Re: Proposed Section 96 (1A) Modification to SSD 5237-2012 Wagga Wagga Base Hospital Phases 2 and 3

In November 2013, the above application was approved for the Wagga Wagga Health Service Redevelopment (WWHS). SSD 5237 dealt with Phases 2 and 3 of the hospital redevelopment and included:

The purpose of this letter is to outline the amendments proposed and to assess the impacts of these changes on the environment.

2 ACUTE HOSPITAL PRECINCT EAST ELEVATION

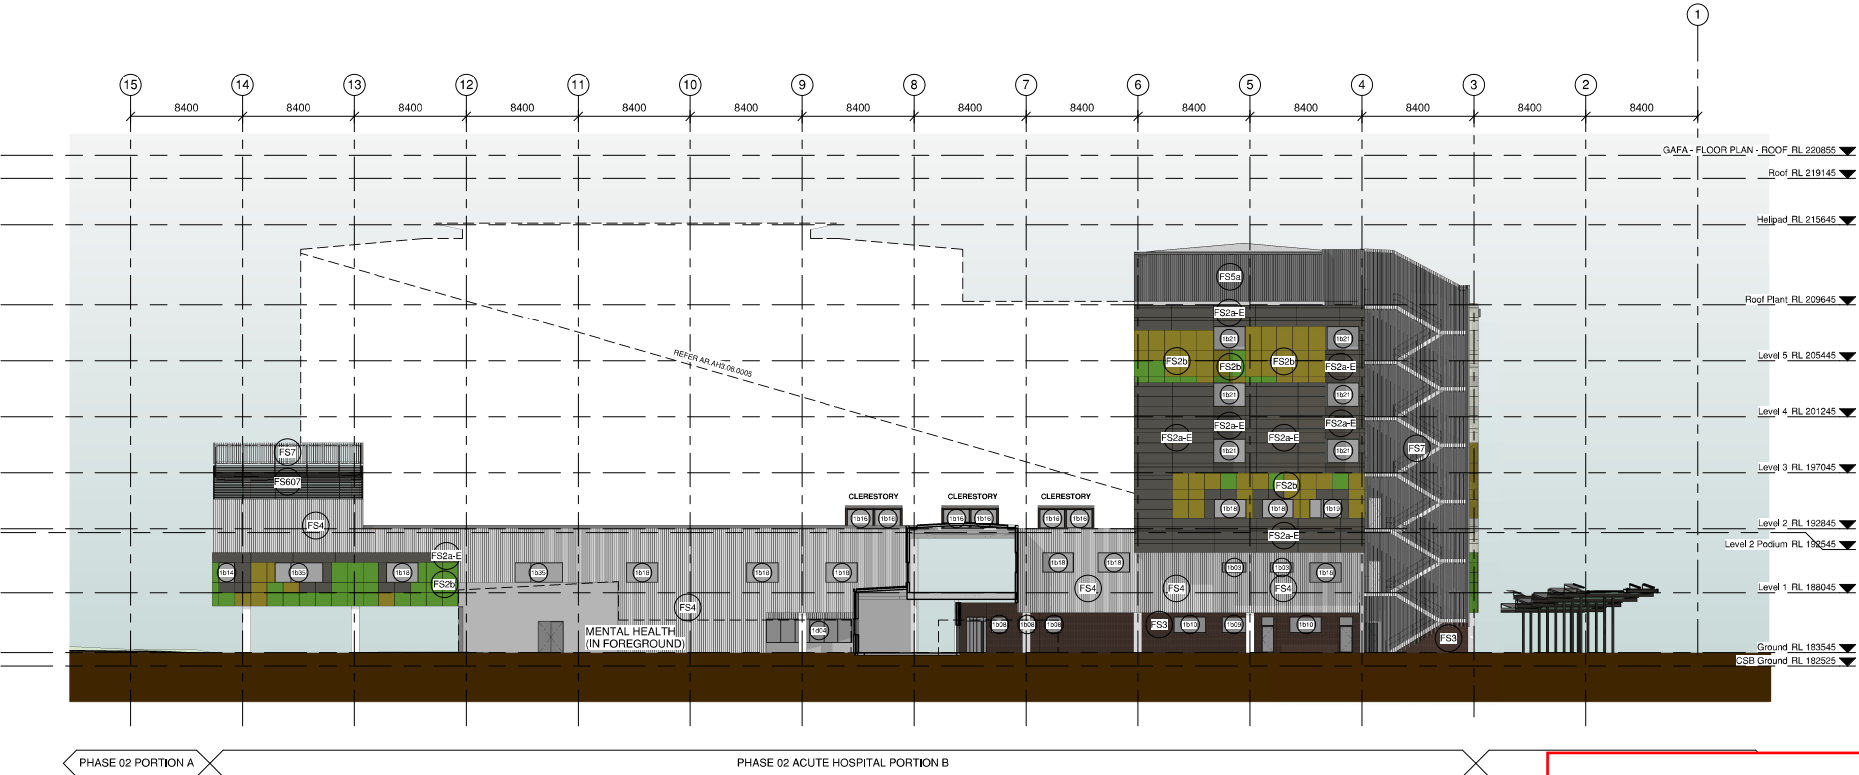
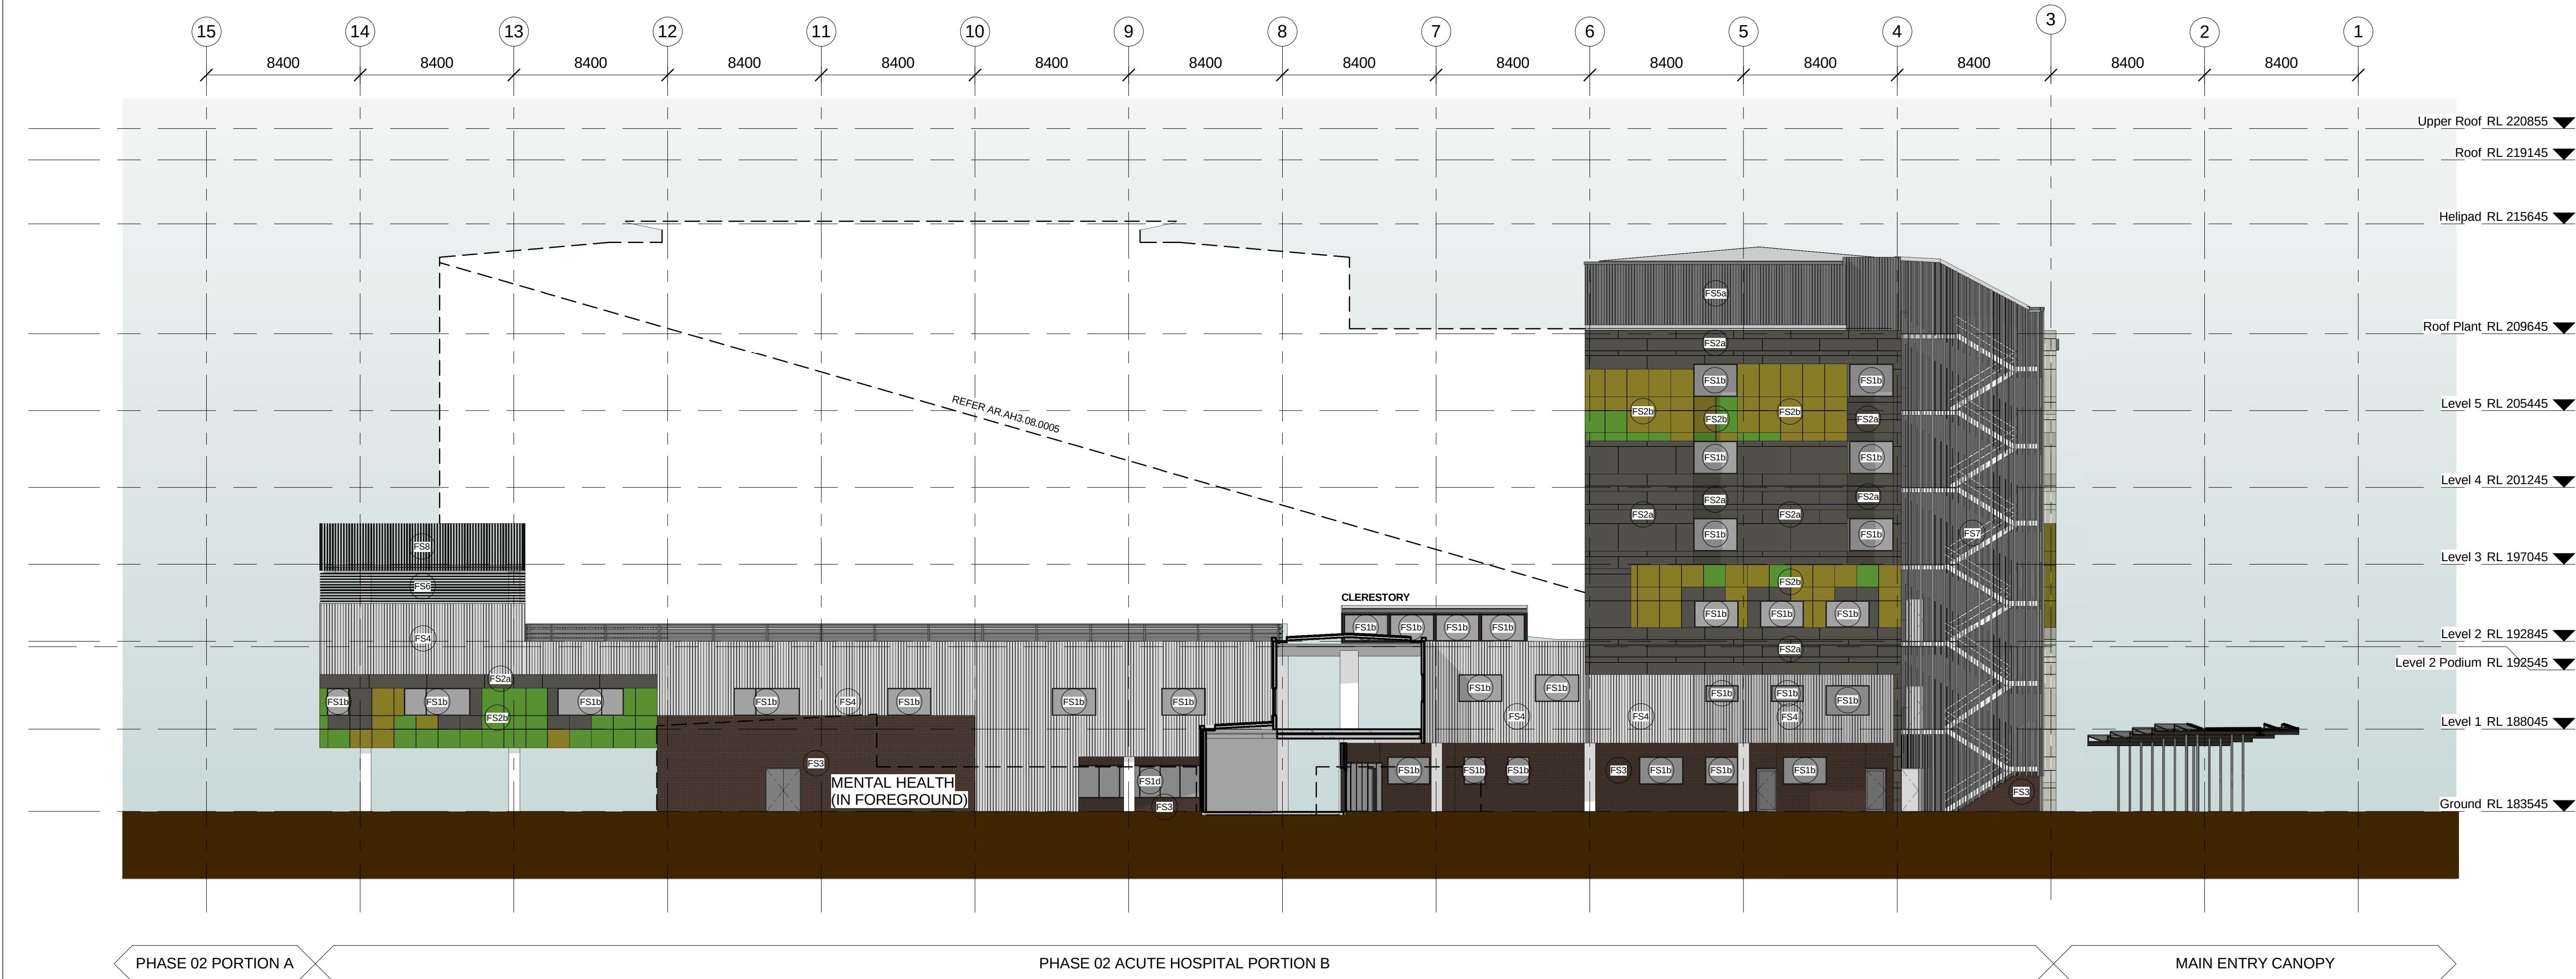
The material Terracade (ceramic tile cladding system) & anodised aluminium façade cladding has been replaced with an aluminium composite panel (ACP) system. The vertical sun shade fins have been deleted. The façade panel break has altered to suit the new cladding material. There is no change in the overall colour scheme. The details of these changes are shown on the attached drawings and comparison sheets (Attachment A).

B ACUTE HOSPITAL OVERALL PRECINCT SECTION B

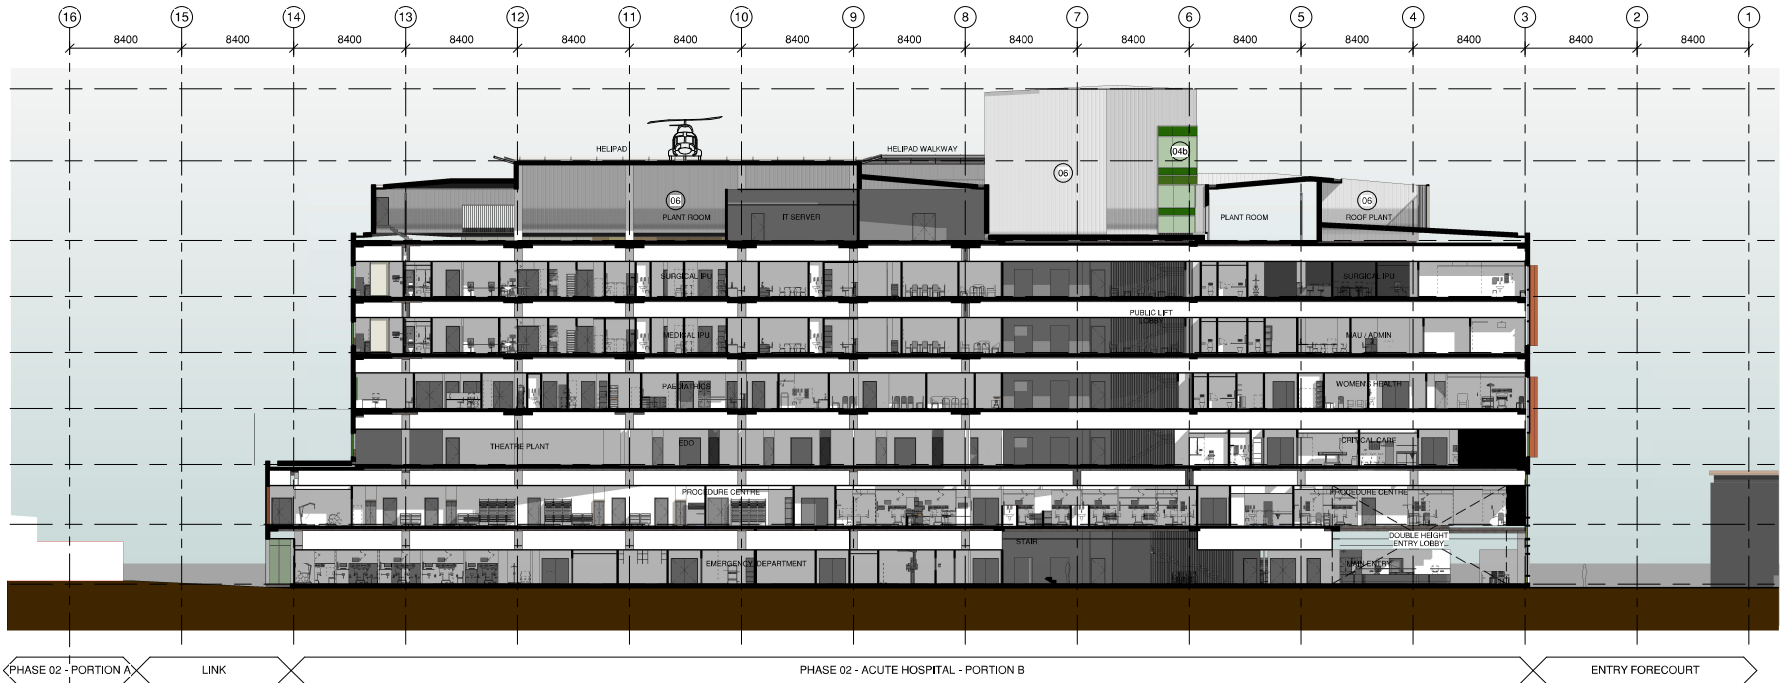
The building floor plate has been raised by 300mm from Level 2 to maximise the freeboard interface with the Level 2 podium green roof. All floors above that have been raised as a consequence increasing the maximum height of the building by 300mm to RL 220855. An increase of 300mm to the overall height of the building is not considered to have an impact. Revised shadow diagrams have been prepared and are attached that indicate that the shadow impacts of this amendment are negligible.
